21 December 2022

Our Reference: SYD20/01120/03

Departments Reference: SSD-9577613

EXHIBITION OF EIS AMERICOLD PROSPECT EXPANSION 554-562 RESERVOIR ROAD - PROSPECT

Figure 1.1: Heavy Vehicle Driveway (existing) SSD assessment

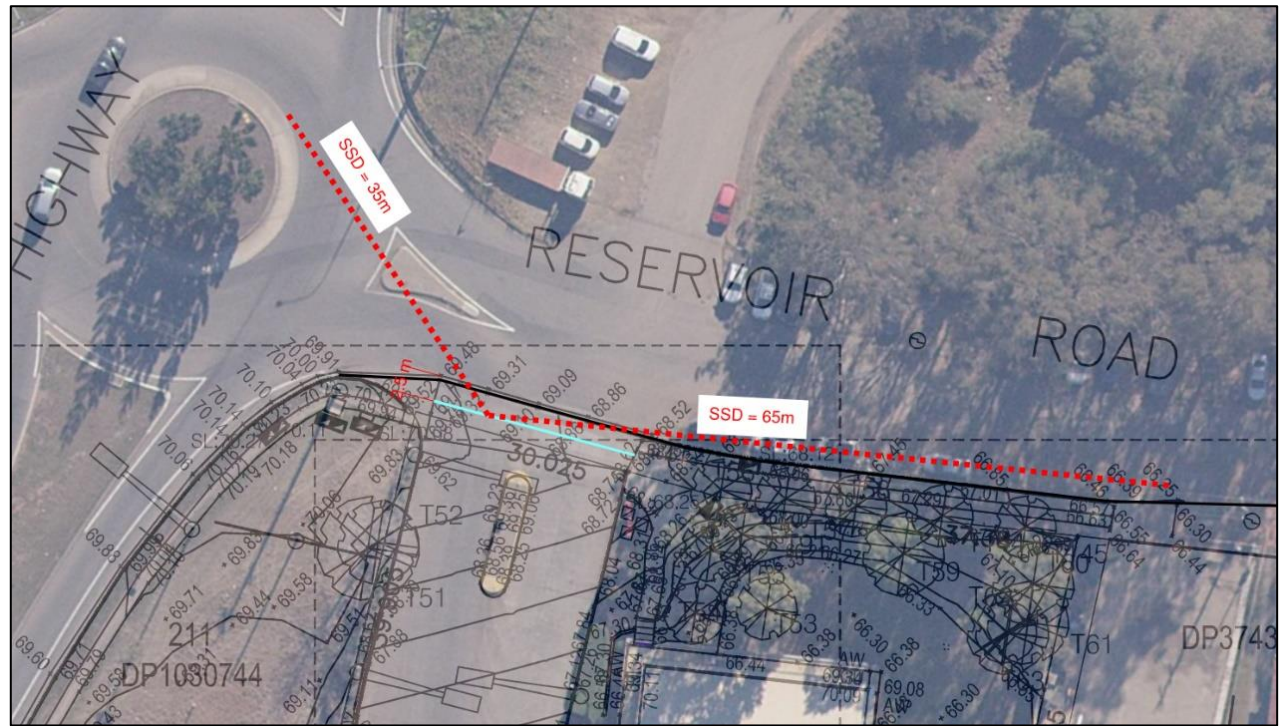
TfNSW has reviewed the submitted documentation and raised significant concerns to road safety in regard to the close proximity of the existing driveway to Prospect Highway. We recognise that issues in relation to access are experienced due to the existing arrangement as well as the expectation of this increasing due to increased development trips and the future intersection upgrade to traffic signals.

Any queue greater than 6 metres on Reservoir Road East on approach to Prospect Highway restricts the right turn into the site from the opposing direction. This is unsatisfactory in regards to traffic signal control where queues through the intersection are expected to occur.

Due to road safety grounds, TfNSW objects to any further increase in traffic generation. Therefore, an alternative access arrangement to the site requires further investigation.

Figure 4.2: Key Travel Demand Management Facilities

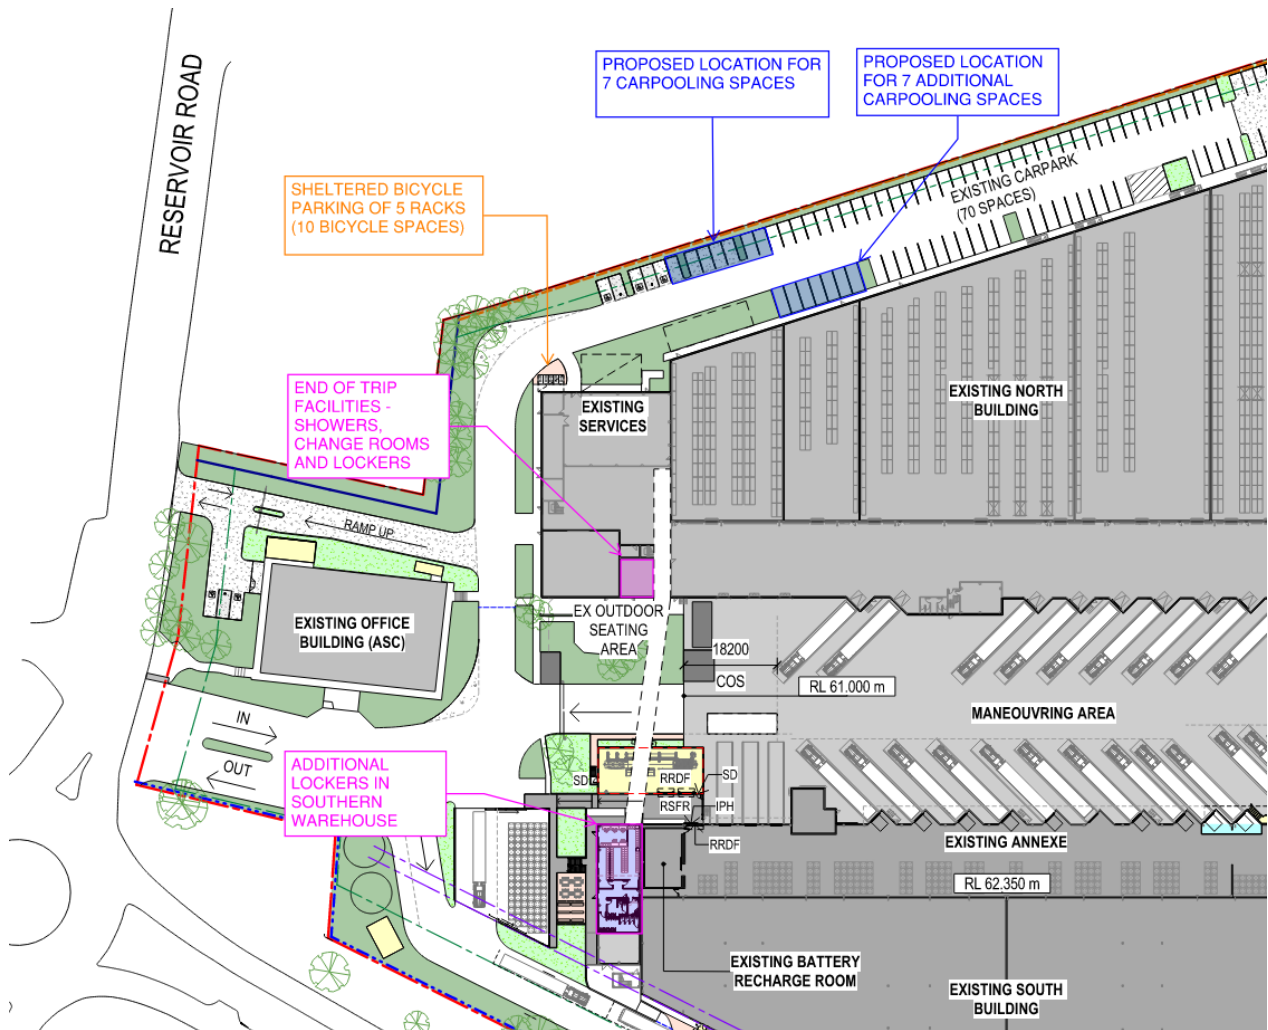
TfNSW appreciates that carpooling is being encouraged (and is already happening), but recommend that the car parking be managed to further encourage carpooling as an option, with dedicated spaces for carpooling – or the most convenient car parking reserved for carpooling.

TfNSW appreciates there is some, albeit limited, parking for bicycles at the northern of the site. TfNSW recommend that the bicycle parking be increased, to encourage more cycling use, particularly as the cycling infrastructure is improved in the future. TfNSW notes that no end of trip (EoT) are provided and recommend that EoT are provided – including showers and lockers to further encourage cycling as a viable mode of transport. This could include providing incentives for e-bikes for longer distances, and well as emerging micro mobility options. TfNSW recommend that this bicycle parking and any EoT be monitored over time to ensure sufficient supply to encourage active transport both to/from the site, for employees and visitors. Investigation into other possible bicycle parking locations around the site
